CITY OF ALBUQUERQUE

May 25, 2018

RE: **McDonalds – Menaul and San Pedro**
5900 Menaul Blvd NE
Site Plan for Building Permit
(Non-stamped) Plan Date: 5/16/18 (File: H18D070)

Based upon the information provided in your submittal received 6/13/17, the Grading and Drainage Plan cannot be approved until the following are addressed:

DESIGNED		MAR 2023		HJM	
DRAWN		MAR 2023		HJM	
CHECKED		MAY 2023		TNT	
AS-BUILT					
GRADING PLAN					
C7.0

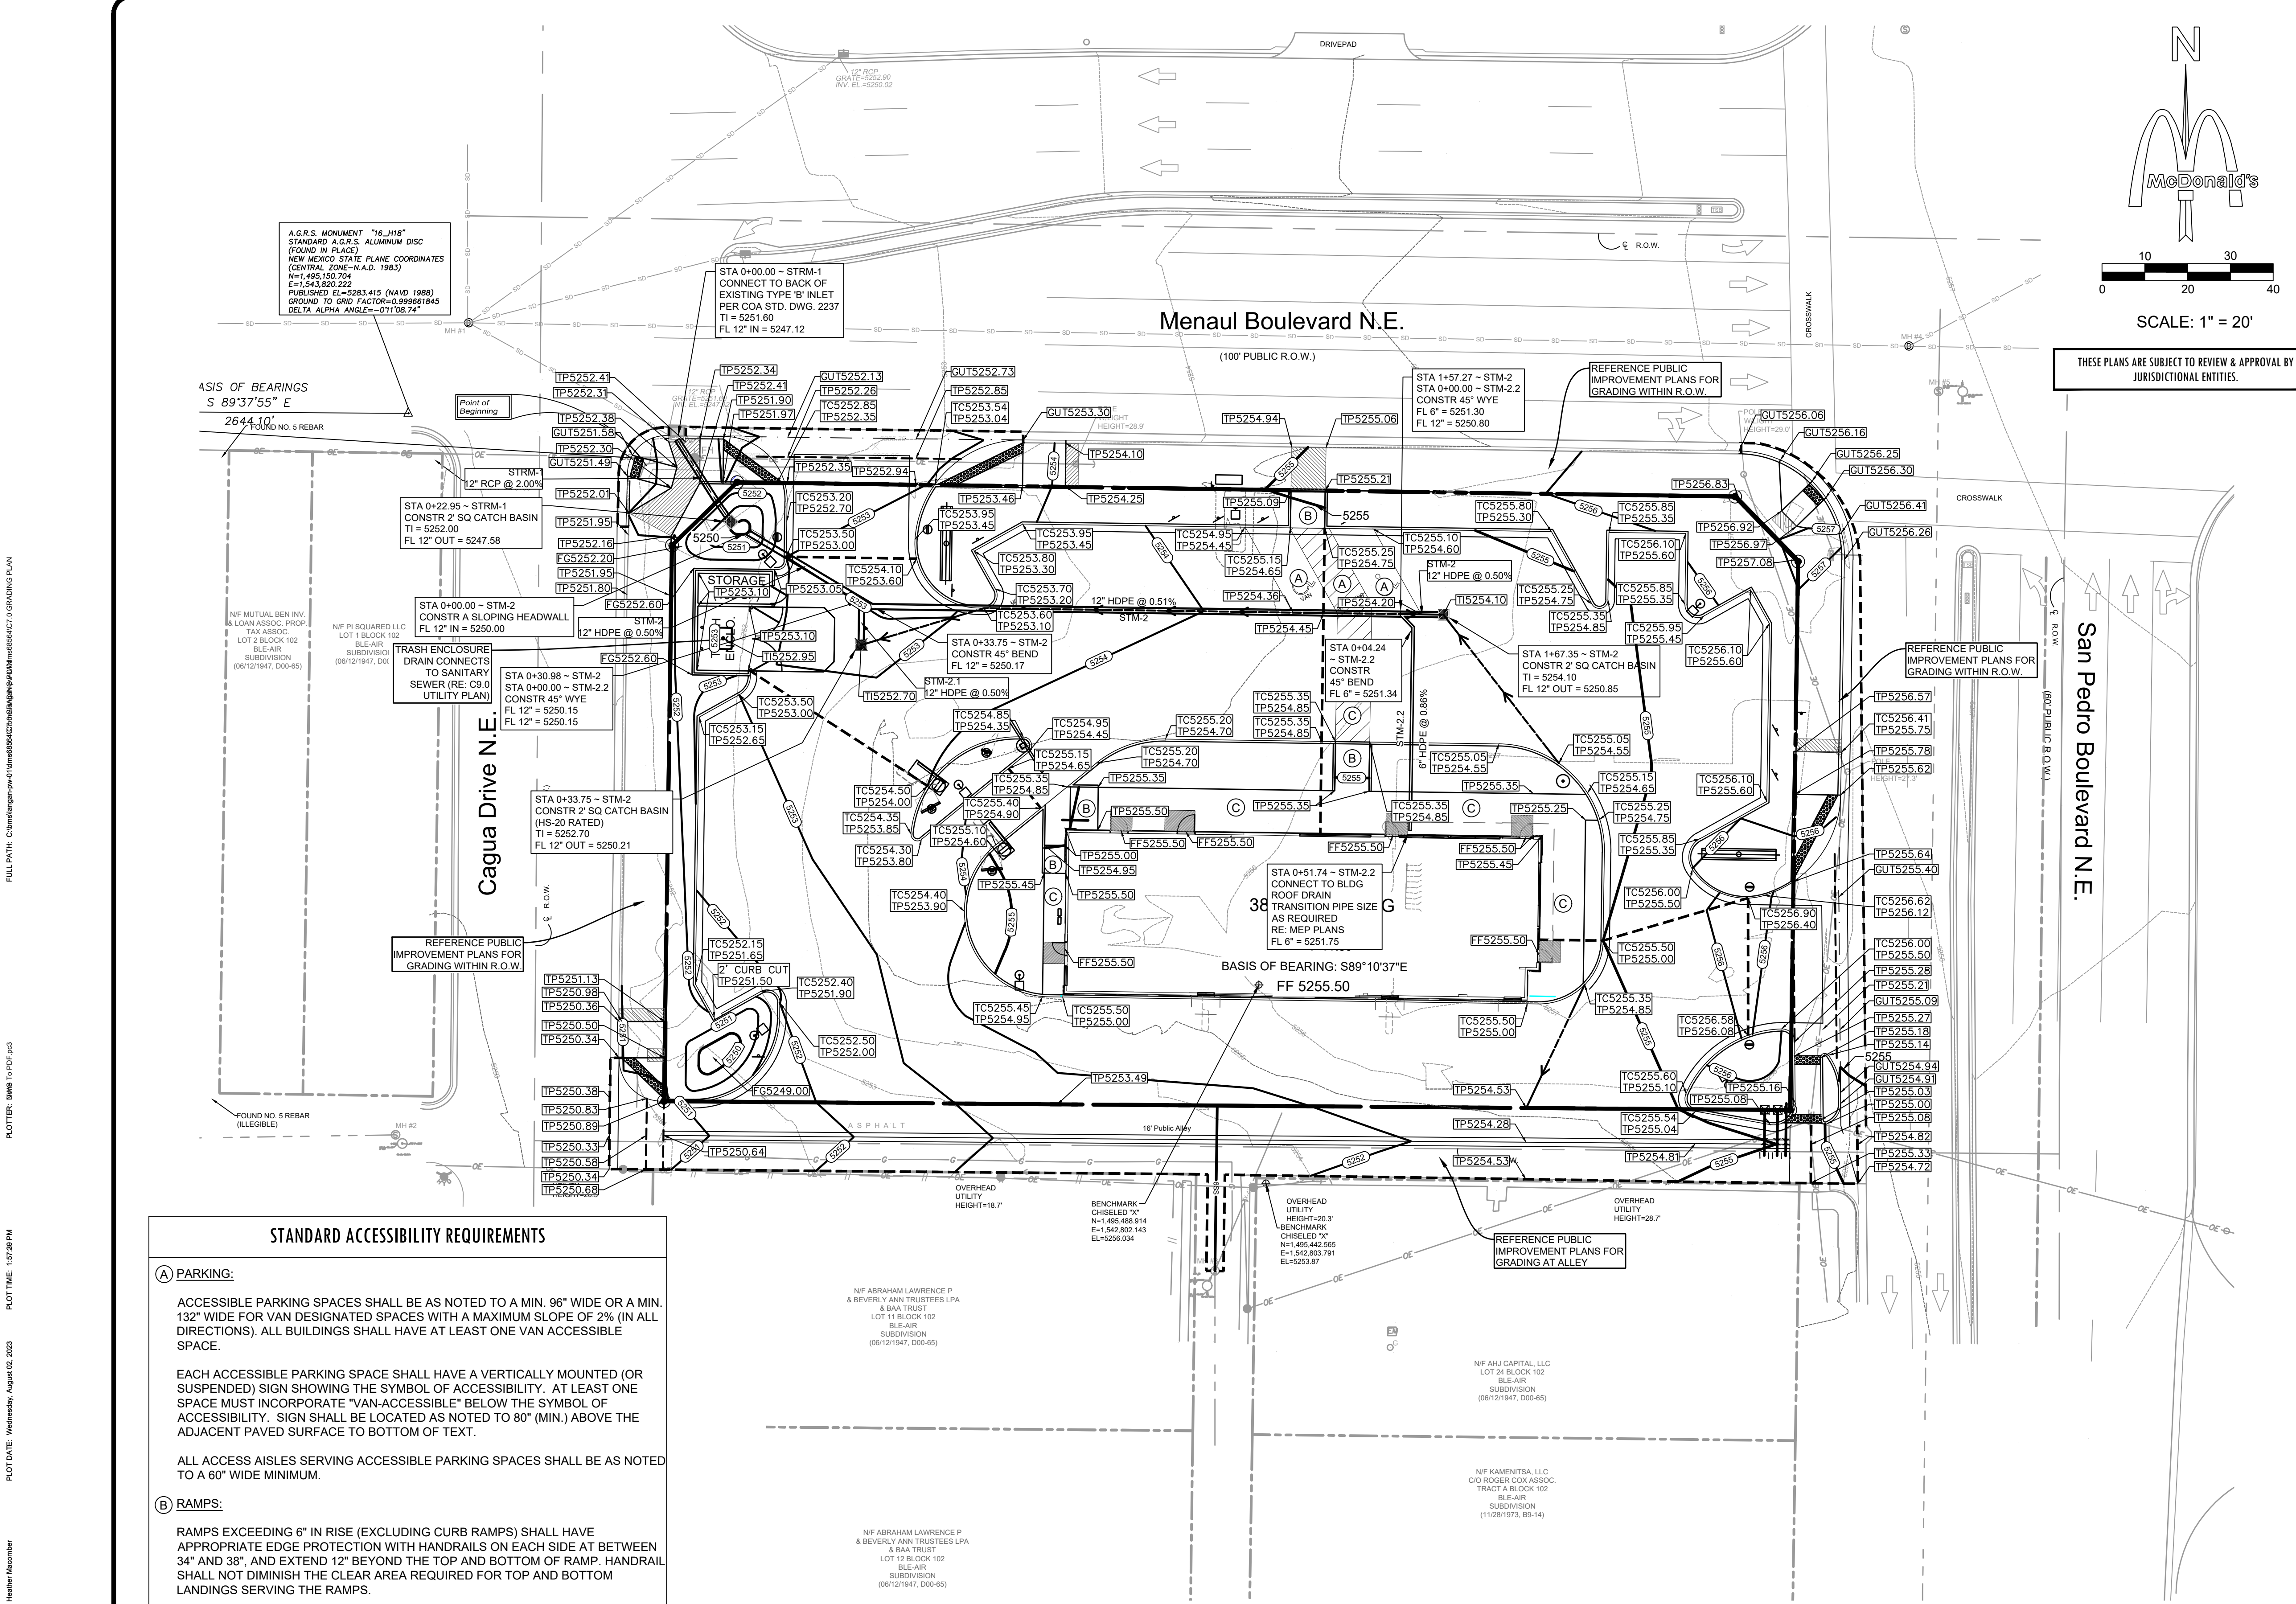
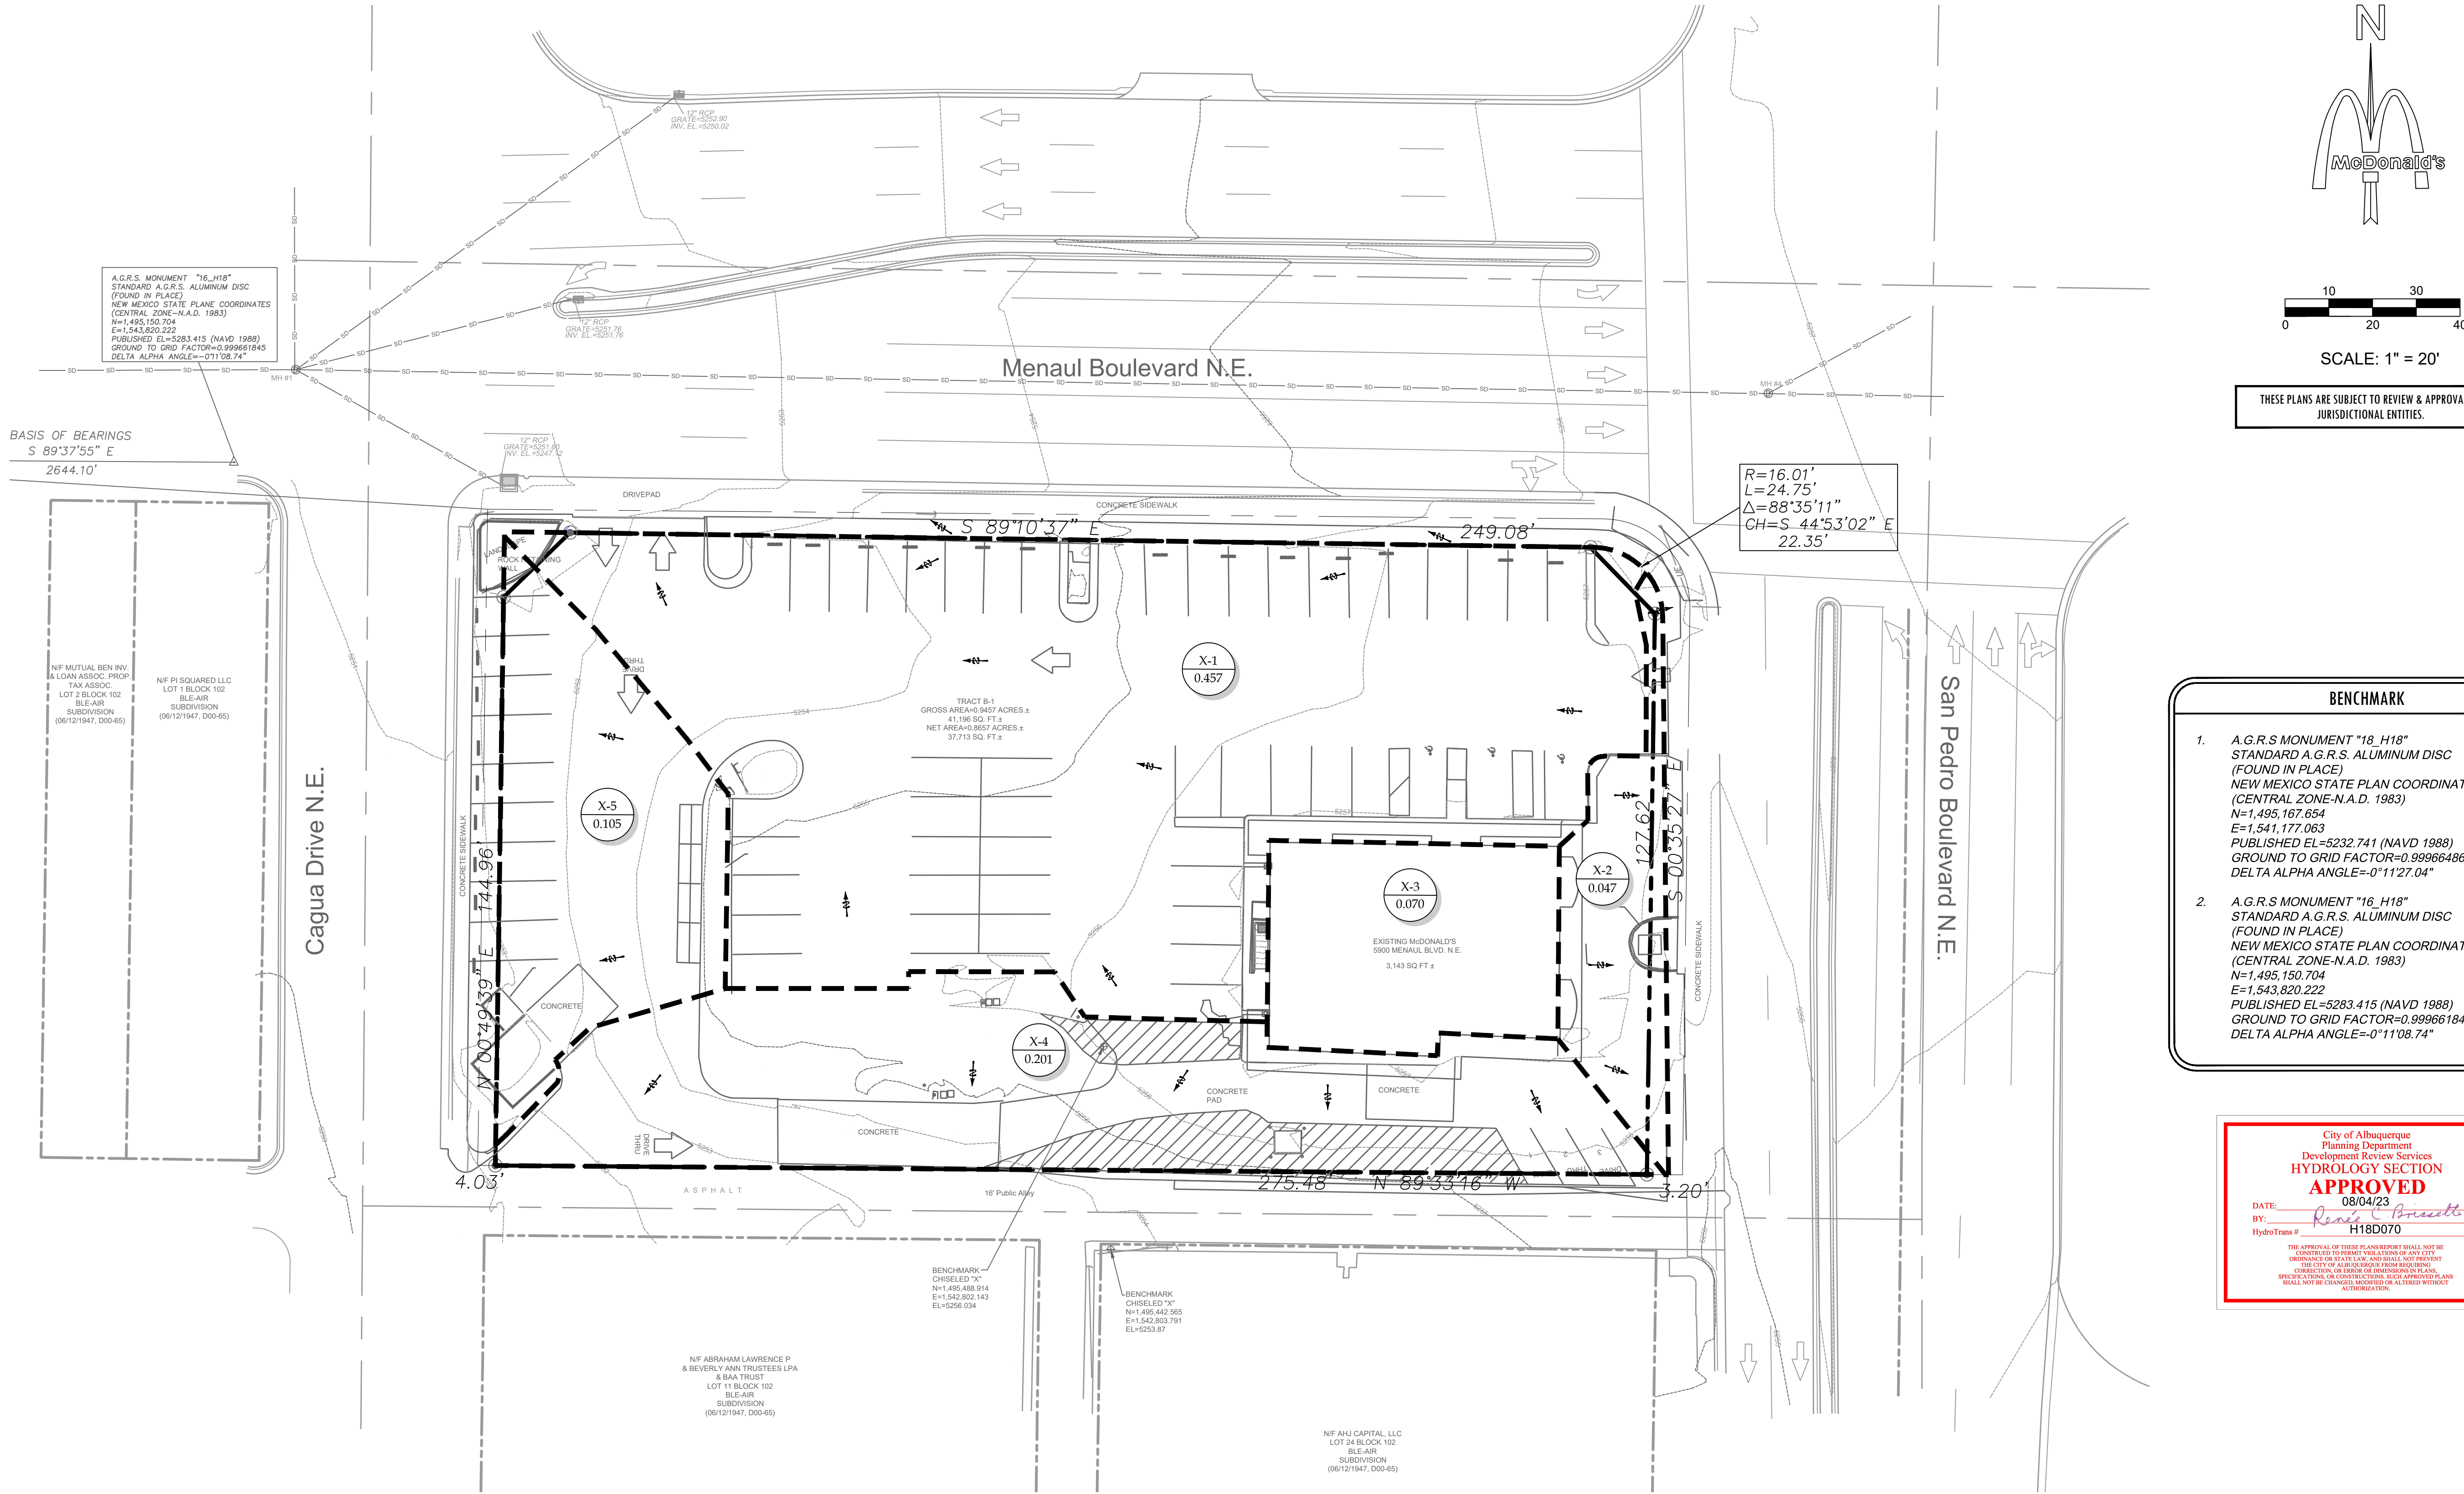
1. How will flows discharge from the ponding areas to the public ROW (sidewalk culverts, tie-in to existing drop inlets)? Discharging across sidewalks is not acceptable.

2. This site qualifies as redevelopment and is only required to retain runoff from the 80th percentile storm (Vol. = 0.26”*Imp.Area).
3. If pond 3 cannot be upsized to retain the contributing first flush requirement, payment of Fee-in-Lieu for the bypass volume may be made at a rate of \$8/cf.

4. Basin DA-4 needs to be routed through a first flush pond. Alternatively, payment of Fee-in-Lieu for this bypass volume may be made at a rate of \$8/cf if unable to pond on-site.

5. If selecting the Fee-in-Lieu option for portions of this site, state the bypass volume on plans; payment of the Fee-in-Lieu will then be required at the time of Building Permit.

8. Waterblocks, 12" high from top of pavement on the drivepad to bottom of gutter along the road, need to be incorporated at the San Pedro entrance.
9. This work will require an Erosion and Sediment Control Plan submitted to the storm water quality engineer (Curtis Cherne, PE, ccherne@cabq.gov) before Building Permit Approval.

10. The Grading and Drainage Plan will need to be sealed by the Engineer prior to approval by Hydrology.
11. For trash enclosures serving food service developments, please include a drain line to a grease trap and then drain into the sanitary sewer. If this information is on the utility plan please provide it, or show on the grading plan.
